March 14, 2018

**RE: PUDSP-16-003-Lorson East Grading and Utilities First Submittal -
Review Comments Response Letter**

Grading and Erosion Control Plan / SWMP (School Site)

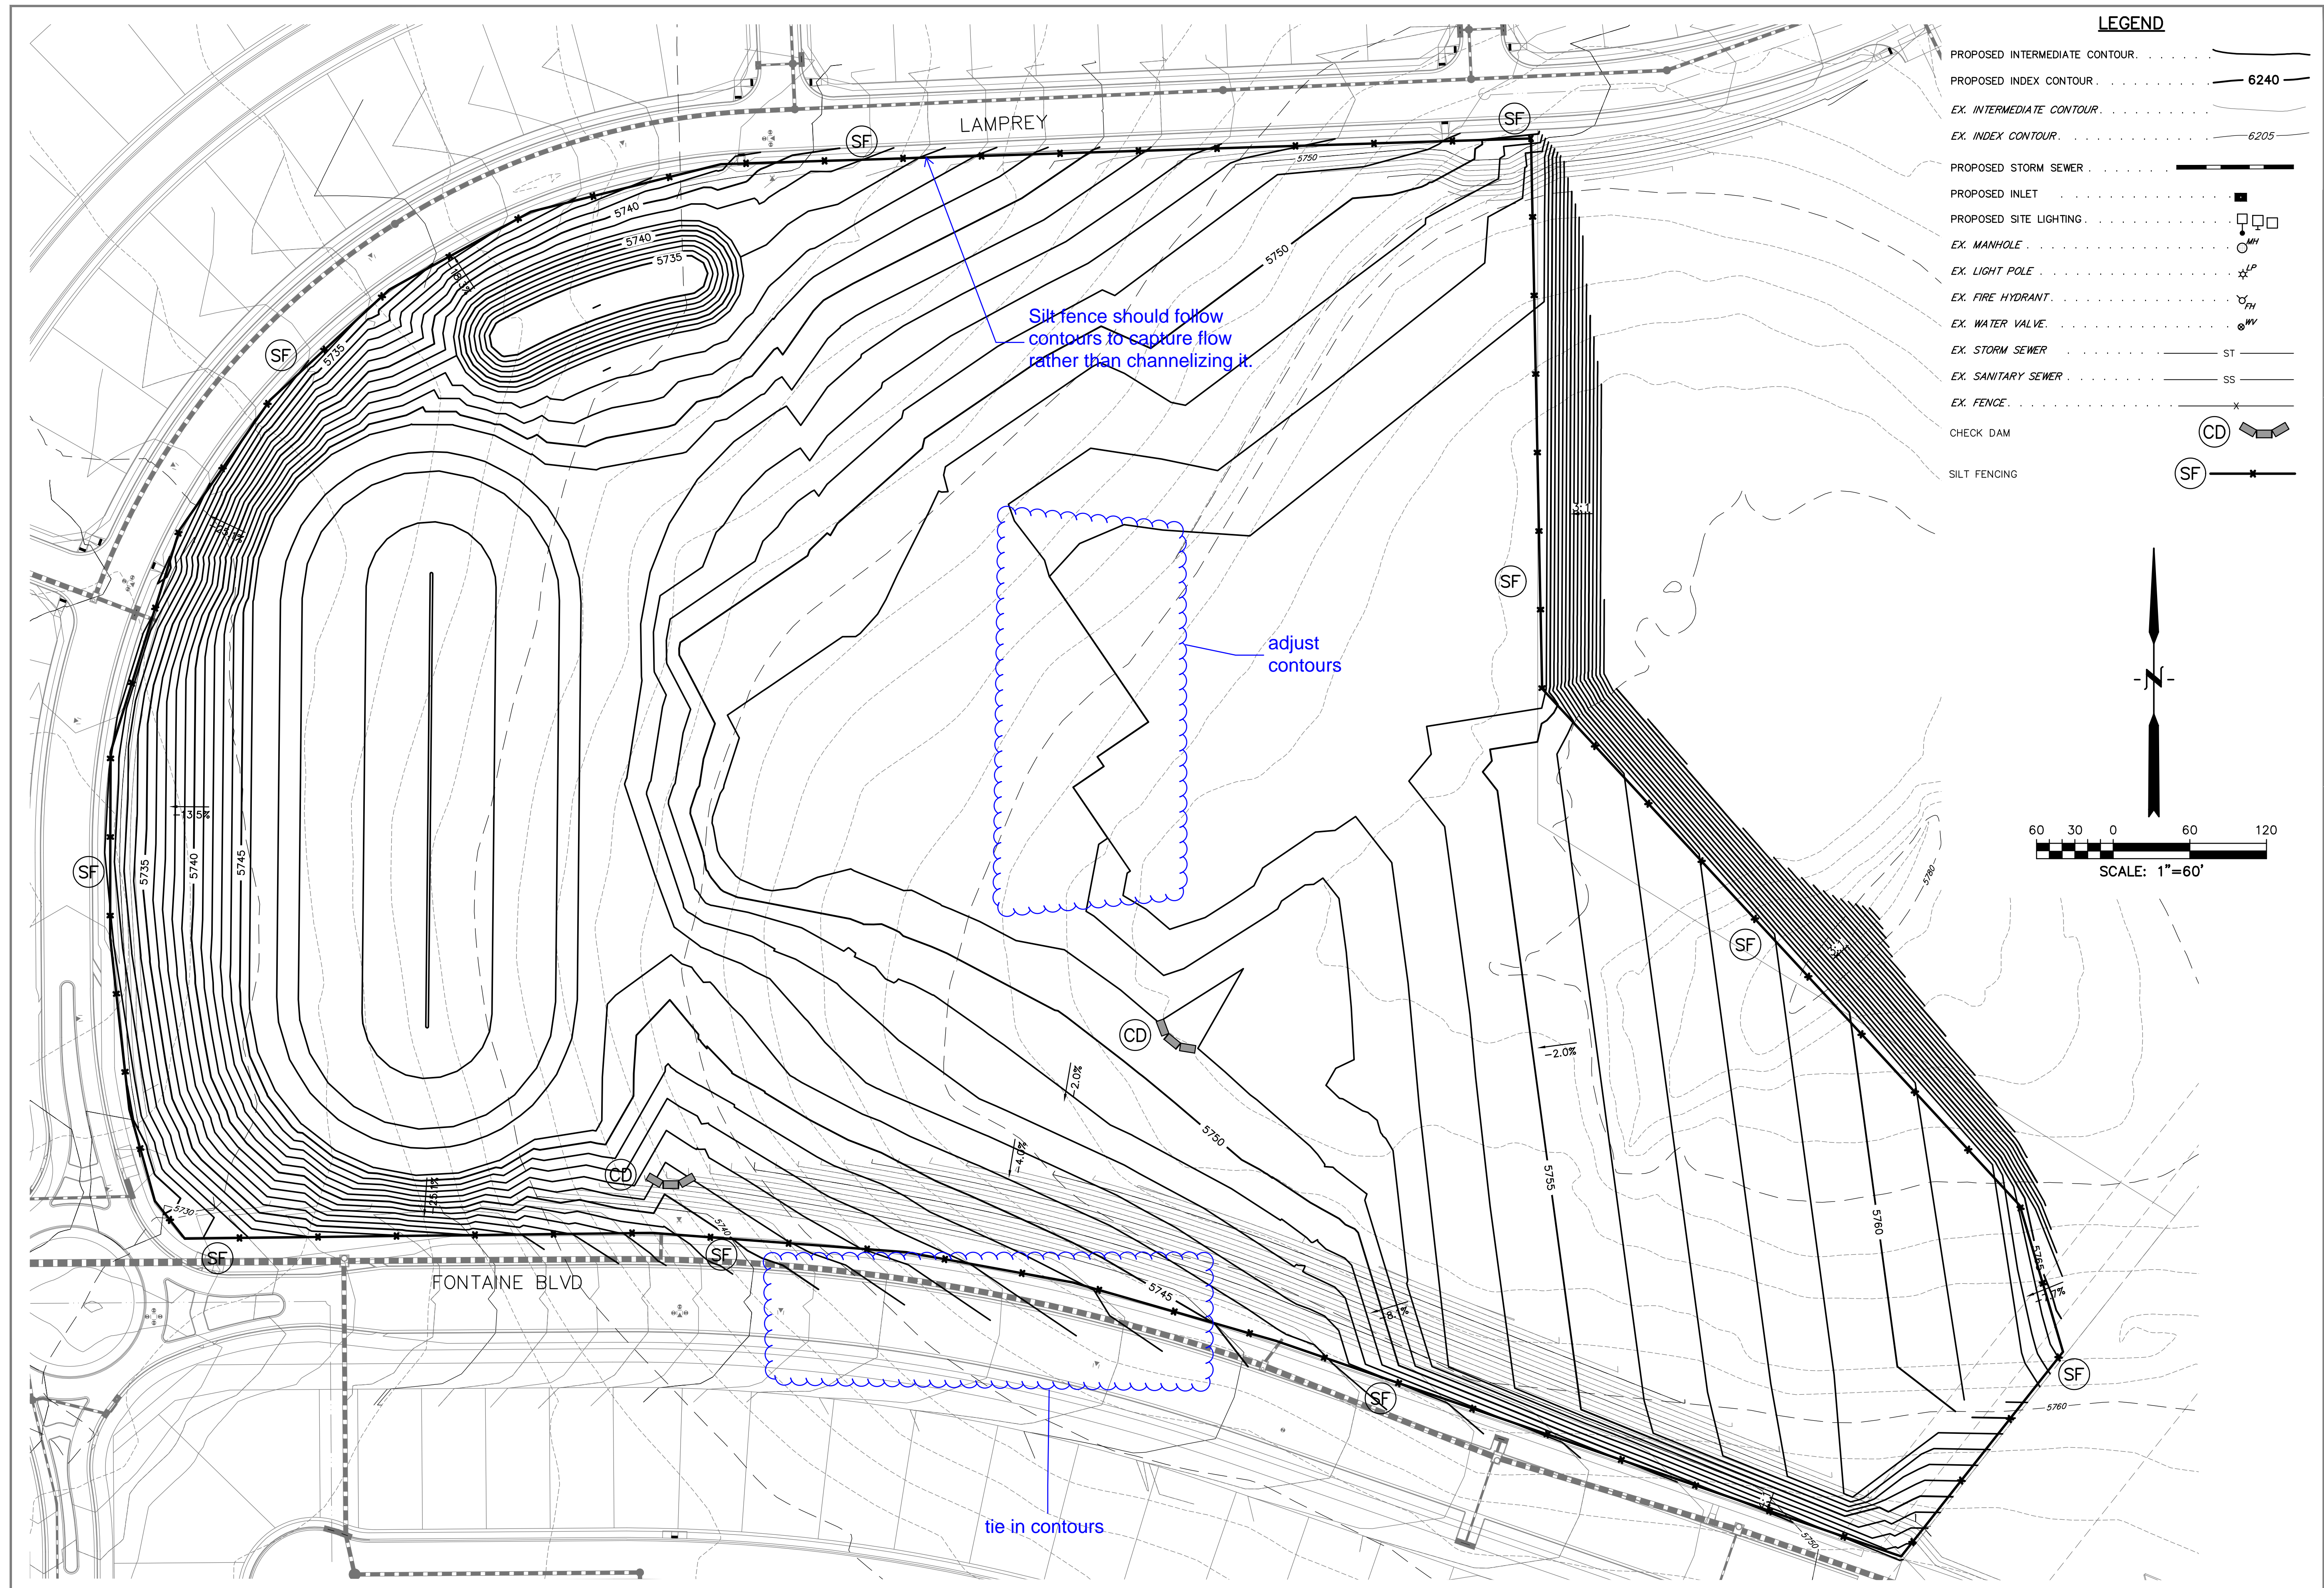
1. Provide P.E. signature and stamp on all sheets with the final submittal. ***Included***
2. Provide a boundary/limit of disturbance for the disturbed area under the school district's responsibility and label as such. ***Limits of disturbance now shown & labeled***

3. See electronic GEC plan redlines for additional comments and questions. ***Comments have been addressed.***
4. Provide a separate SWMP and ESQCP for the school site if this work will be under the school district's authority and contracting. If the school district will be responsible for providing fill or stockpiling in a specific area (such as opposite Lamprey from the school parcel), provide those sheets showing any additional phasing as well. If Lorson Ranch will maintain responsibility for the fill areas outside of the school site provide a note stating this. ***SWMP & ESQCP have been provided. Note has been added to plan stating that the school district is responsible for the area within the limits of disturbance and Lorson Ranch is responsible for anything outside of those limits after the initial export grading.***
